**KIRKLEES METROPOLITAN COUNCIL
INVESTMENT & REGENERATION SERVICE**

Reference No:	2025/62/90765/E
Site Address:	24, Pollard Avenue, Gomersal, Cleckheaton, BD19 4PP
Description:	Erection of single storey rear and side extension
Recommending Officer:	Edward Cheseldine

DECISION – REFUSED

Officer Report

Drawing Name
Proposed Elevations

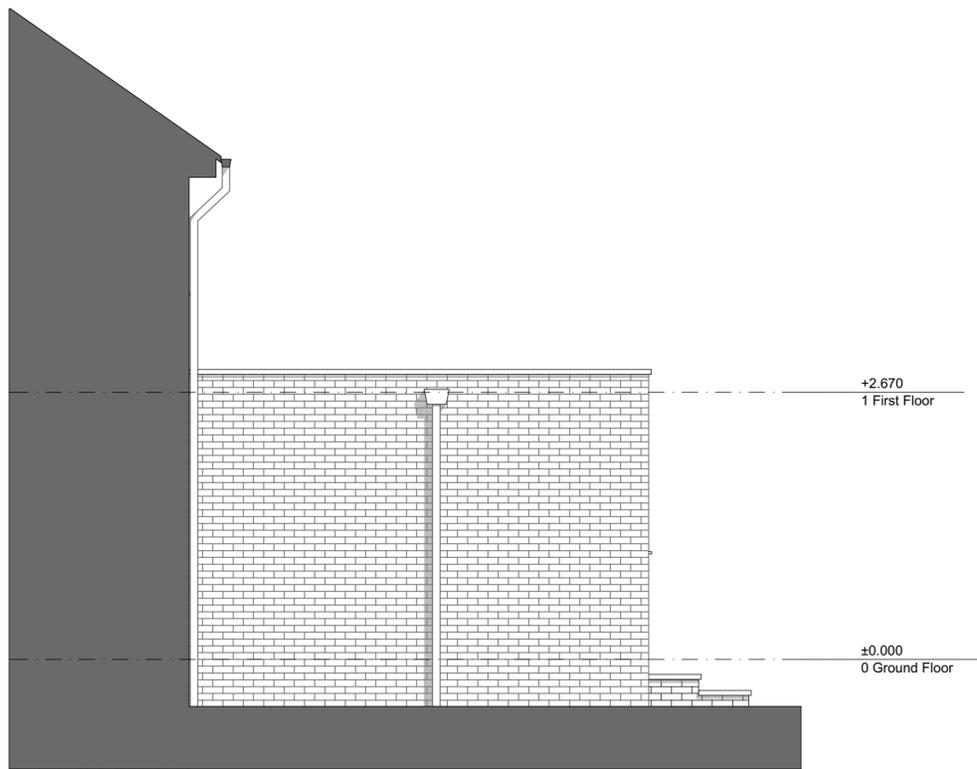
The applicant is seeking permission for the erection of a rear and side extension. The extension will project 4.60m from the existing rear elevation, to a width of 8.10m with a roof height of 3.40m. The extension will be constructed with brown coursed brickwork to match the existing dwelling and will feature a flat roof. It will feature rear facing windows.

The rear extensions footprint will be 37m², set against a property of 54m². The proposed extension has a maximum height of 3.40m. It spreads across the full width of the building with a minimal separation distance from the adjoining property. Part of the extension would project over the edge of the elevation, therefore being visible from the Pollard Avenue. Whilst this element will be visible, it will be set back behind the dwelling. The extension will appear large, however given its simple form it is considered to be acceptable from a visual amenity point of view particularly as materials are to match the existing.

In terms of a loss of light, outlook or an overbearing impact, the rear extension will be erected along the boundary with a 0.20 side space remaining. Plans indicate this will be 4.60m along the boundary, at a height of 3.30m. The nearest habitable window at 22 Pollard Avenue is 1.20m away, which serves a dining room. The relationship is close.

Due to the projection, proximity to the adjoining property and height of the extension, the proposal would result in a reduced outlook and a loss of light to the inhabitants of 22 Pollard Avenue. To overcome this, Officers requested an 45oC outlook line was drawn on plans and submitted, as per figure 9 of the House Extensions and Alterations Supplementary Planning Document. An annotated plan was however not received.

Given the close proximity, height and projection of the rear extension, it is considered that the extension will materially affect the amount of light observed in this room, and form an oppressive / overbearing feature which has a harmful impact upon the outlook from the neighbouring occupiers. The Council's adopted House Extensions and Alterations Supplementary Planning Document sets out that a 45° line when taken from the Centre of the Cill should not be cut.

Although no specific drawings have been provided in this regard, it is clear this line would be cut, the extensions bulk and proximity to the window is considered to be significant in this case resulting in a detrimental impact within a habitable room.

Therefore, the single storey rear extension, by virtue of its close proximity to the adjoining dwelling, height, and projection would lead to an unacceptable loss of light and form an oppressive and overbearing structure having a harmful impact upon the residential amenity of neighbouring occupants of no.22 by reason of loss of outlook, light and overshadowing contrary to key design principles 4, 5 and 6 of the Kirklees House Extensions & Alterations Supplementary Planning Document Policy LP24 of the Kirklees Local Plan and policies within Chapter 12 of the National Planning Policy Framework.

1. The single storey rear extension, by virtue of its close proximity to the adjoining dwelling, height, and projection would lead to an unacceptable loss of light and form an oppressive and overbearing structure having a harmful impact upon the residential amenity of the neighbouring occupants of the adjoining property by reason of loss of outlook, light and overshadowing contrary to key design principles 4, 5 and 6 of the Kirklees House Extensions & Alterations Supplementary Planning Document Policy LP24 of the Kirklees Local Plan and policies within Chapter 12 of the National Planning Policy Framework.
